Our Ref: AW/63/21/NMA

Non-material amendment following grant of AW/308/15/HH to amend shape and scale of window above garage door opening.

1 The Ridings Aldwick PO21 4HP

PROPOSED ELEVATIONS (1/100)

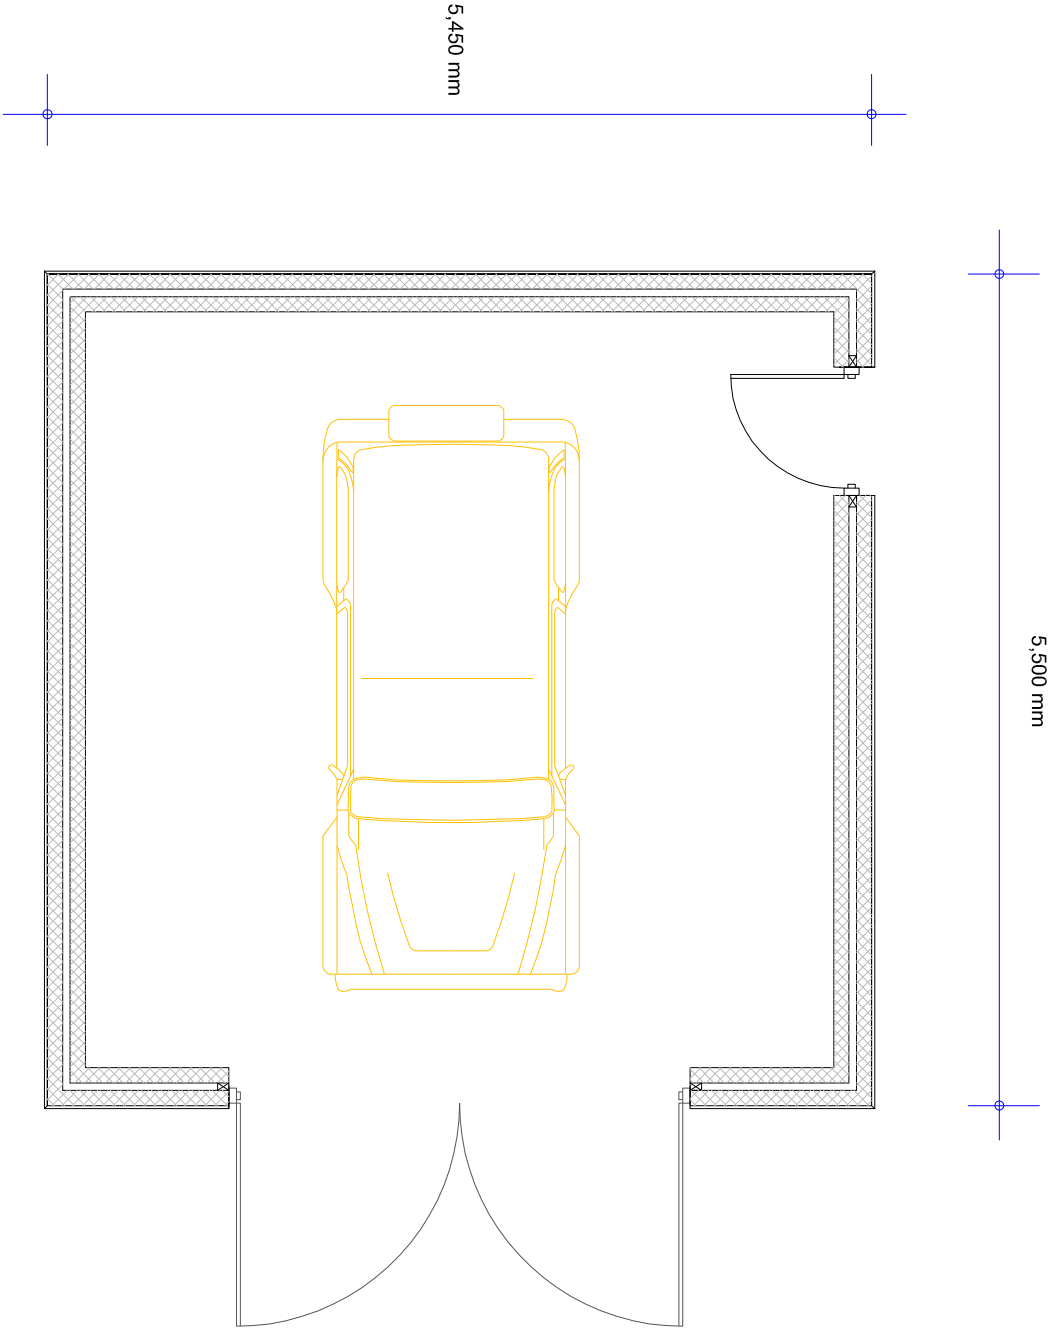
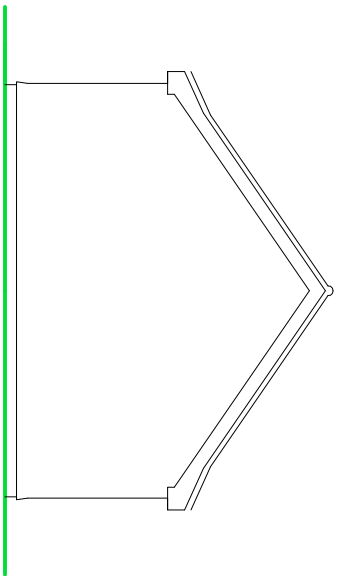
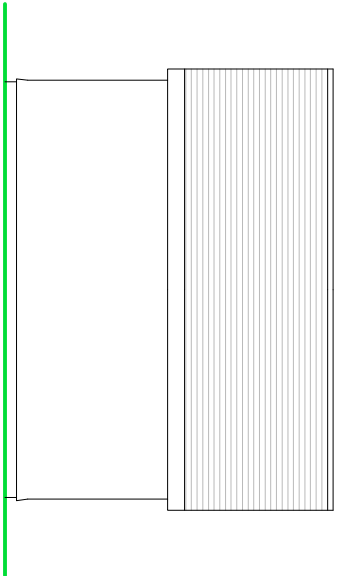
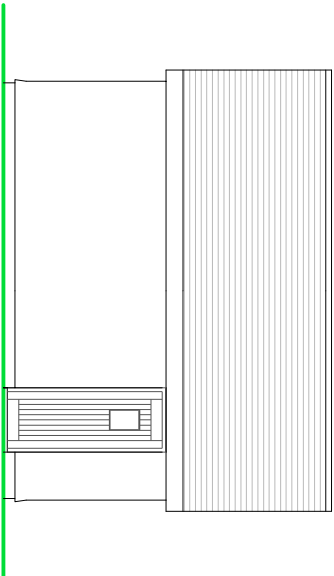
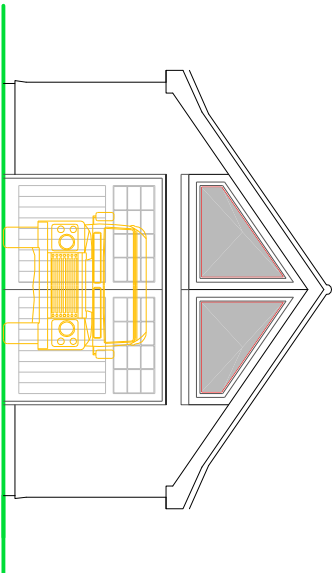
The reasons that this proposal has not been accepted as Non-Material Amendments is because it does not comply with the NMA criteria. Criterion 6 states that the council will not accept the following as an NMA: 'the proposal results in changes to the external details that materially alter the appearance of the building.'

It is proposed to replace the small window above garage doors with a large window of a triangular shape, a glazed gable above the double vertical boarded doors with upper glazed window elements of traditional design. It would materially alter the appearance of the building and it cannot therefore be considered under section 96A of the Town and Country Planning Act 1990.
